From: Simon Davis
Sent: 22 May 2019 16:34
To: Planning Scanning
Subject: FW: Planning Consultation on FP/42/19/DOC

My comments to conditions 7, 9 and 10 are still outstanding, I have not seen any revised details. Condition 8 can be discharged.

Engineers Comments Regarding Condition 7

Project: Wellers Close Hampshire Homes Group	
Drawing: Soft Landscaping Concept	
Date: May 2018	Drawn by: JA
Scale: 1:200 @ A1	Revision: -

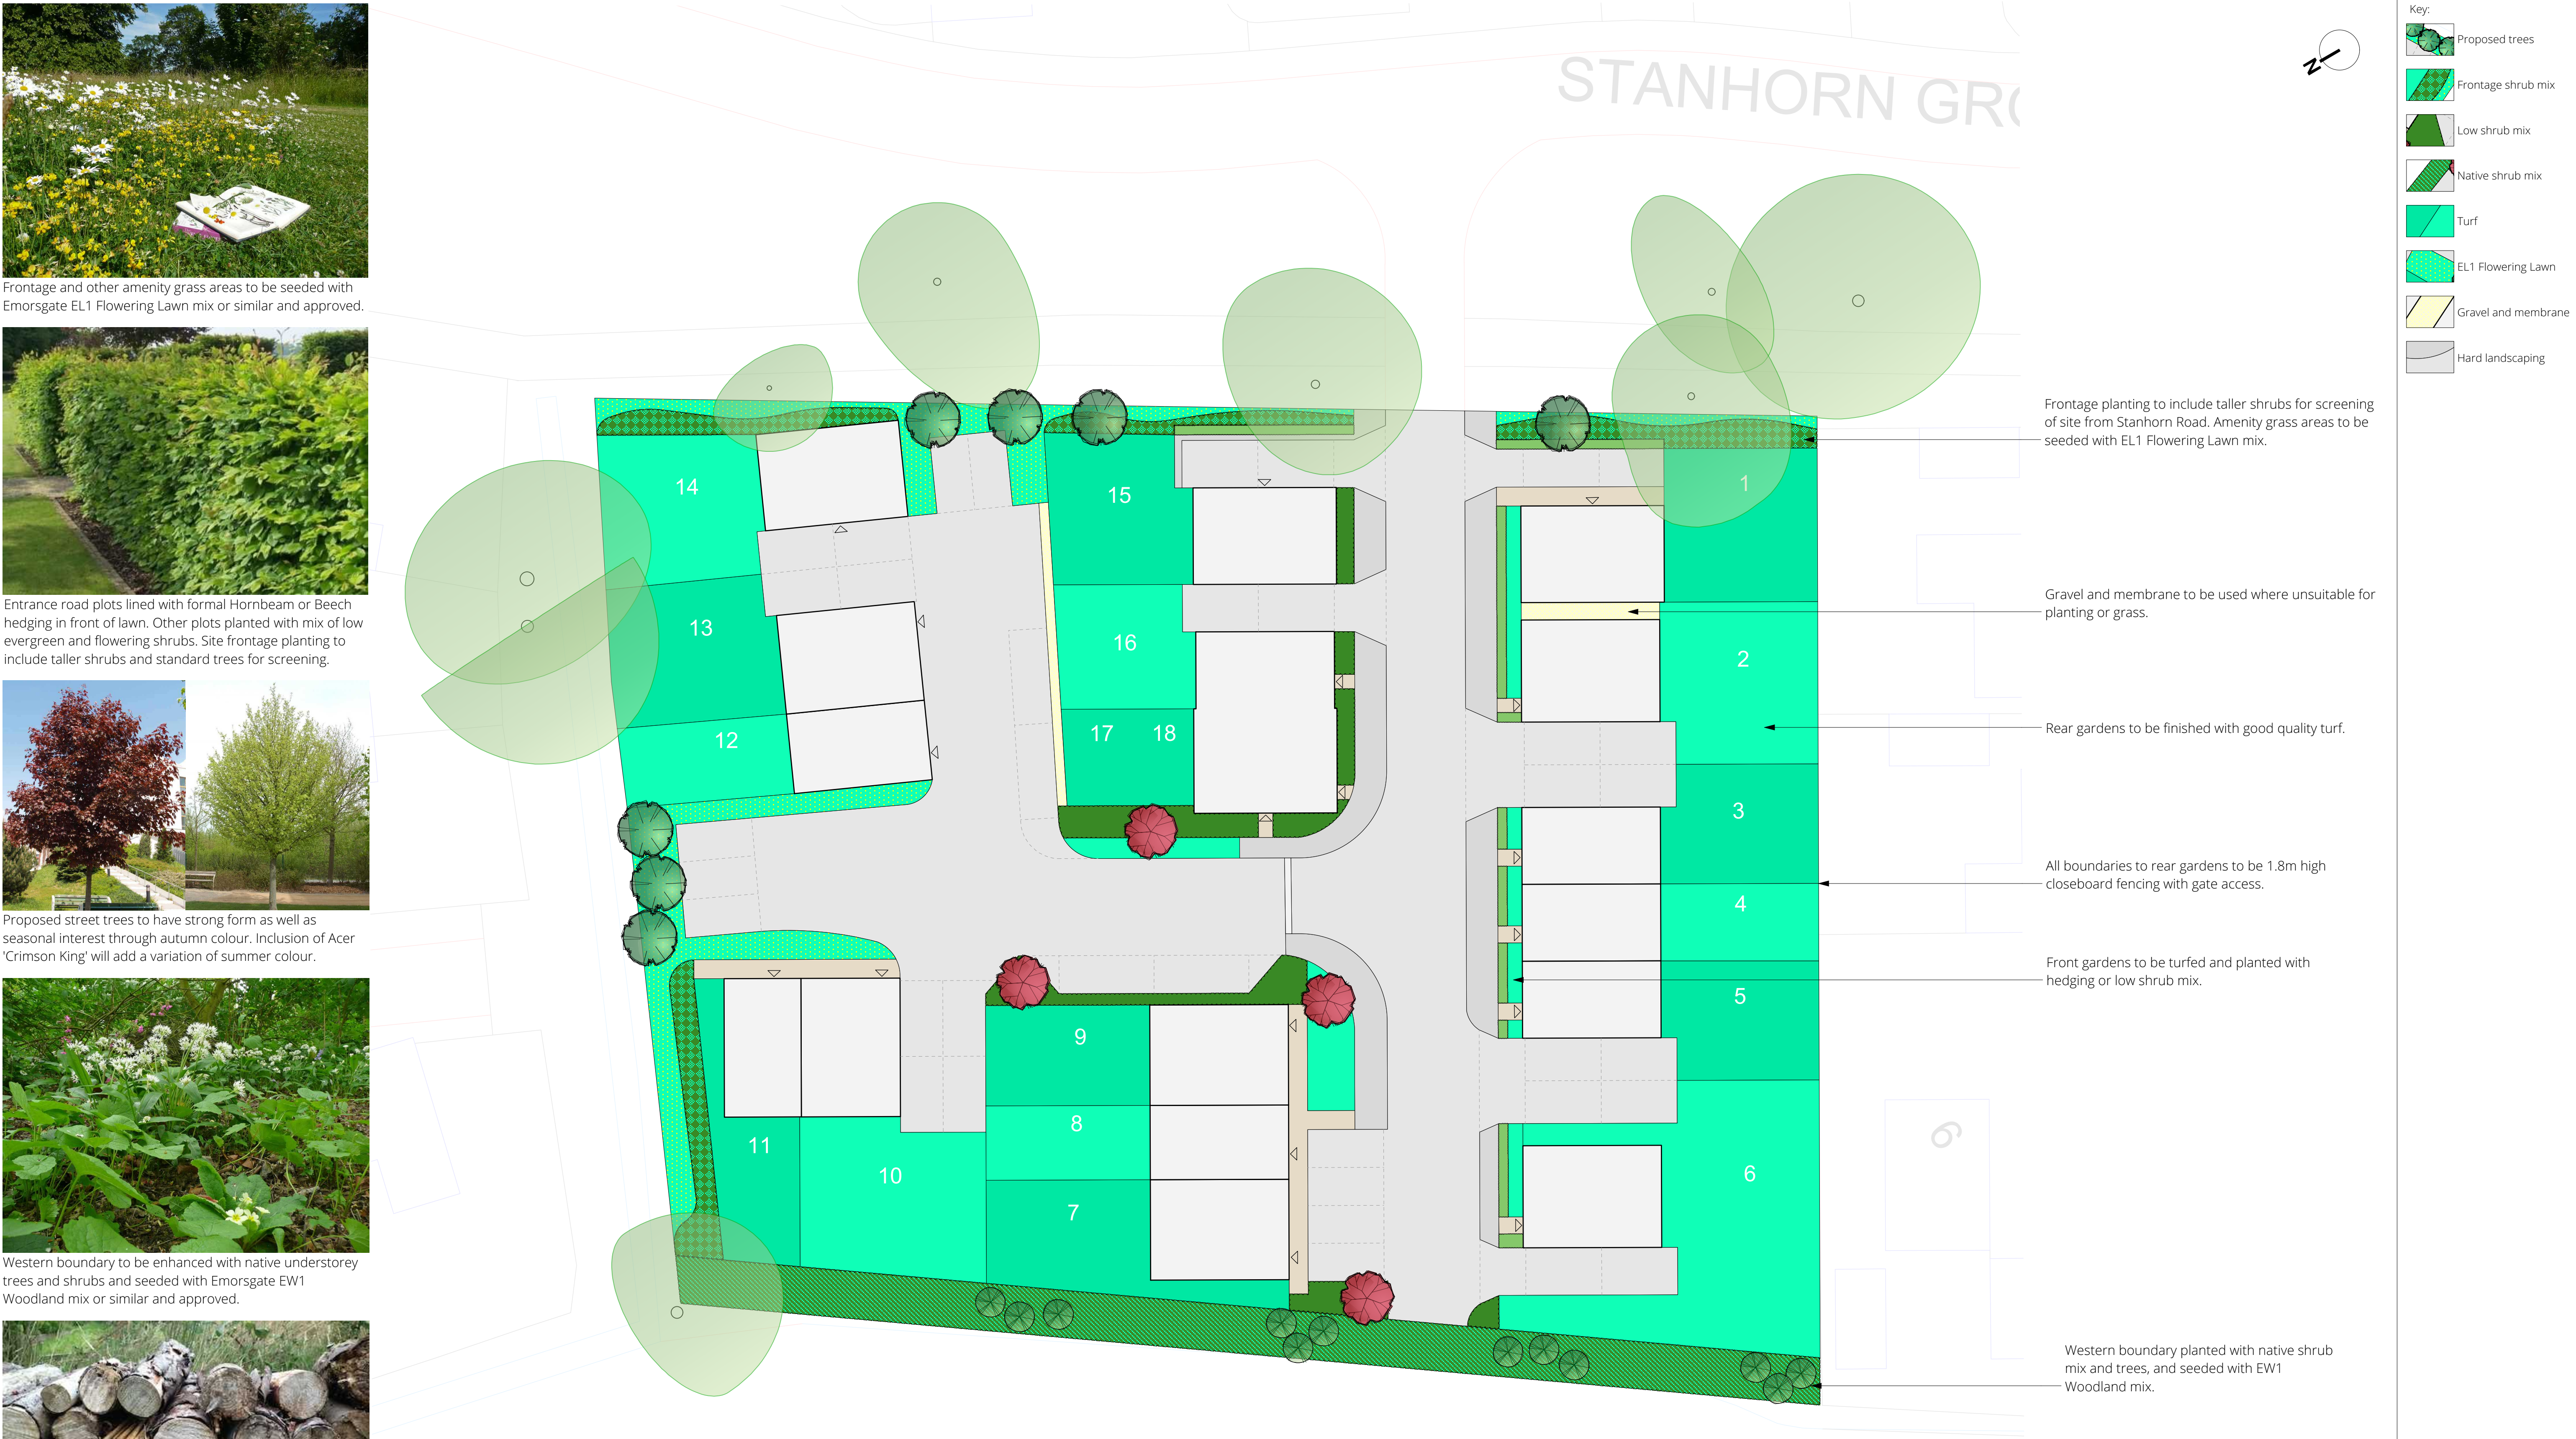
1. Catchpits must be provided upstream of all connections into the attenuation tank.
2. No construction detail drawings have been provided. Please provide construction detail drawings of manholes, catchpits, permeable paving, attenuation tank and hydrobrake.
3. There is conflict between the landscaping proposals and the drainage proposals. Trees must not be located on or near attenuation tanks. Please revise the landscaping proposals.

Rev.	Date	Note	Author	Checked
A	11/06/19	De-mountable fence indicated to rear of Plots 12 - 14	RR	JP

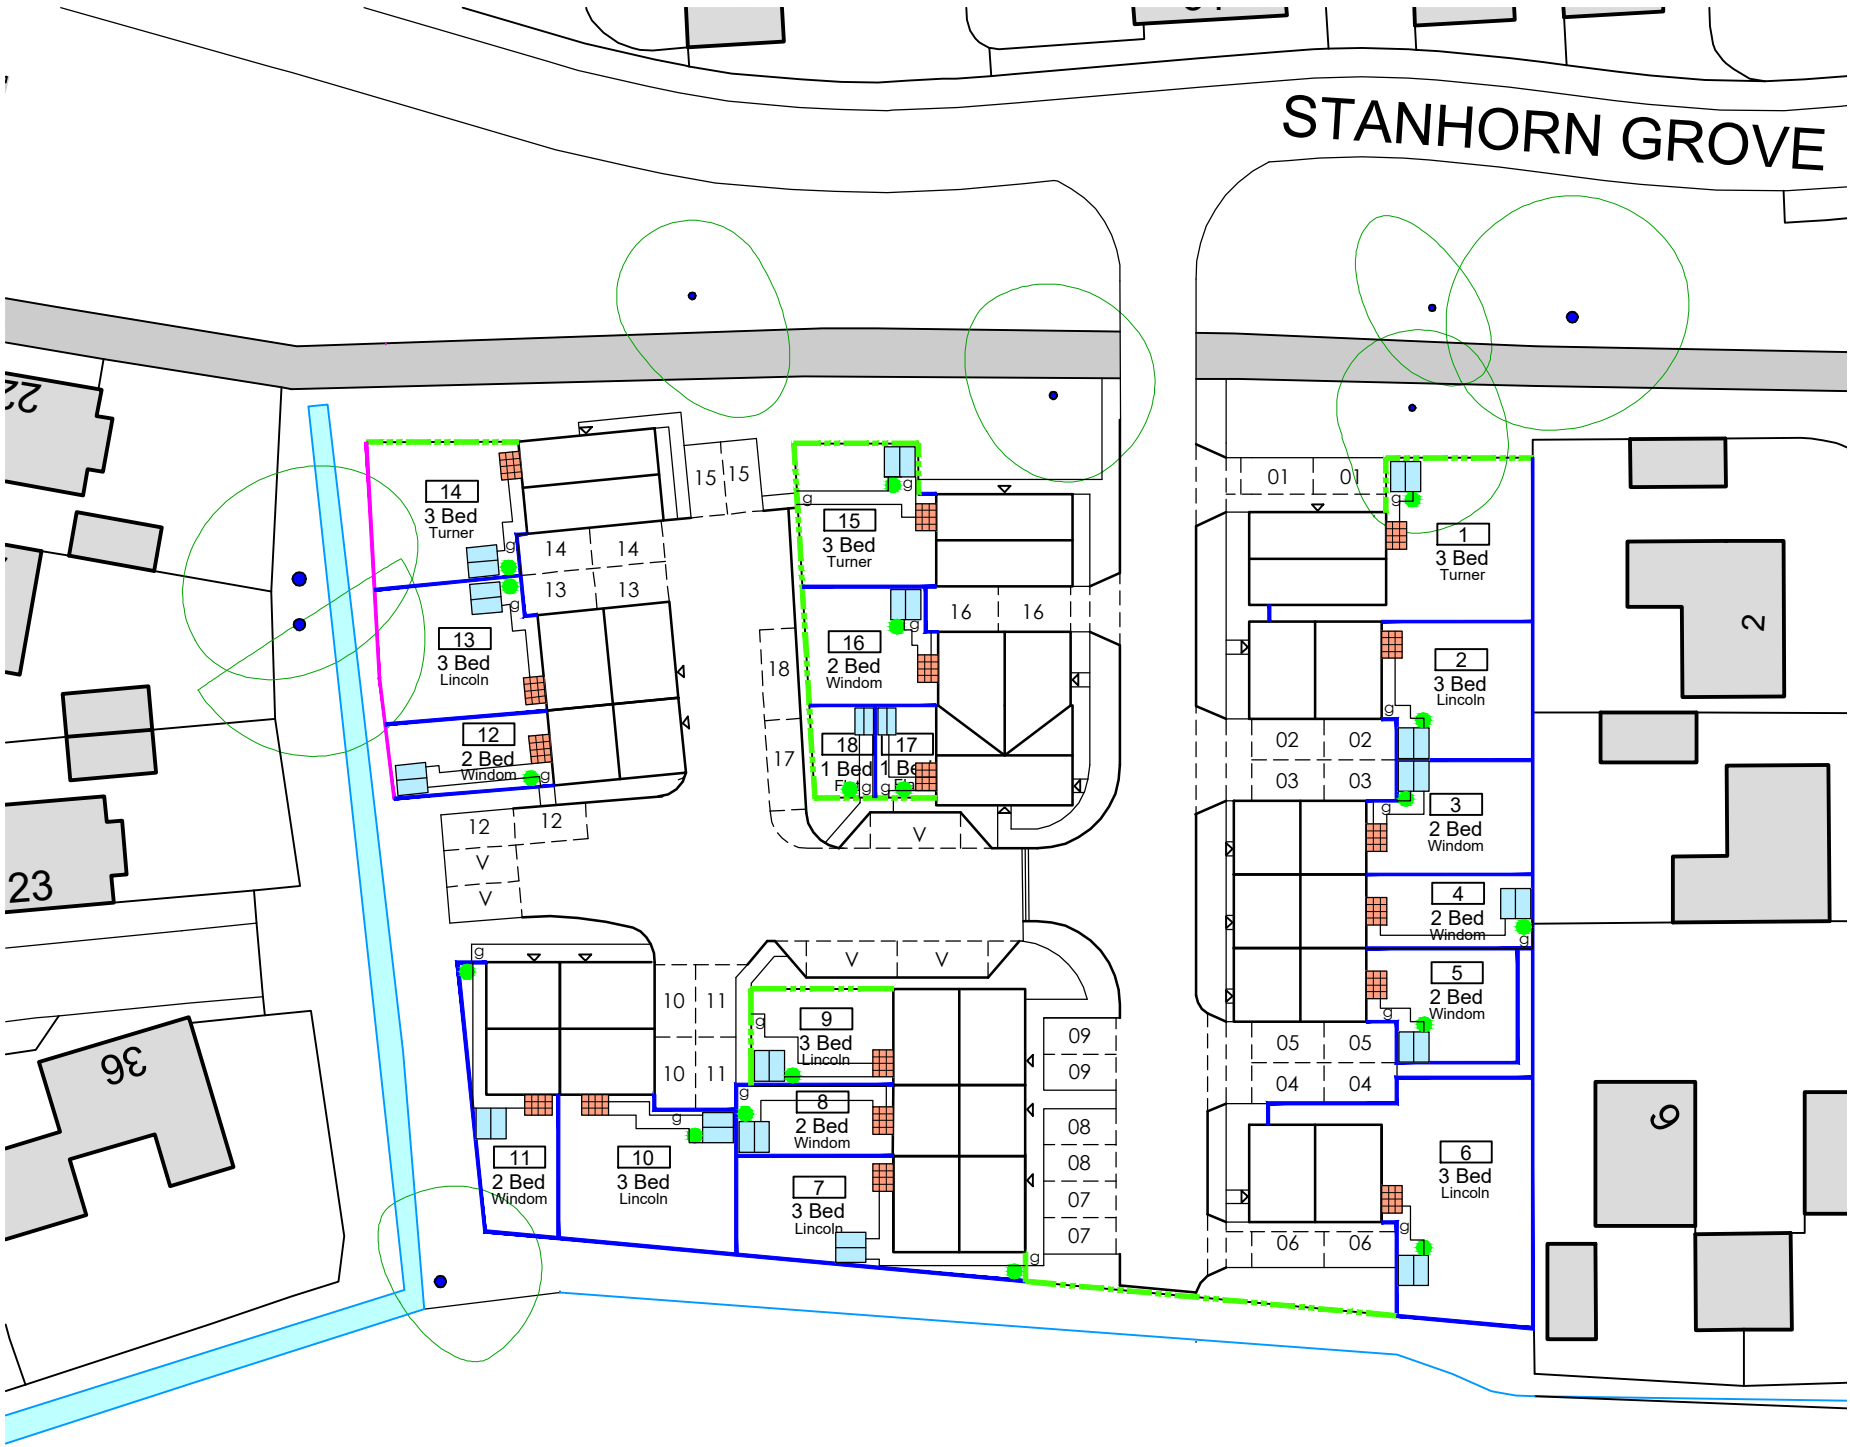
Proposed property boundaries for plots 12-14 need to be amended to allow access to the watercourse. 3m easement is required from any building, fence or wall and the top of bank of an ordinary watercourse.
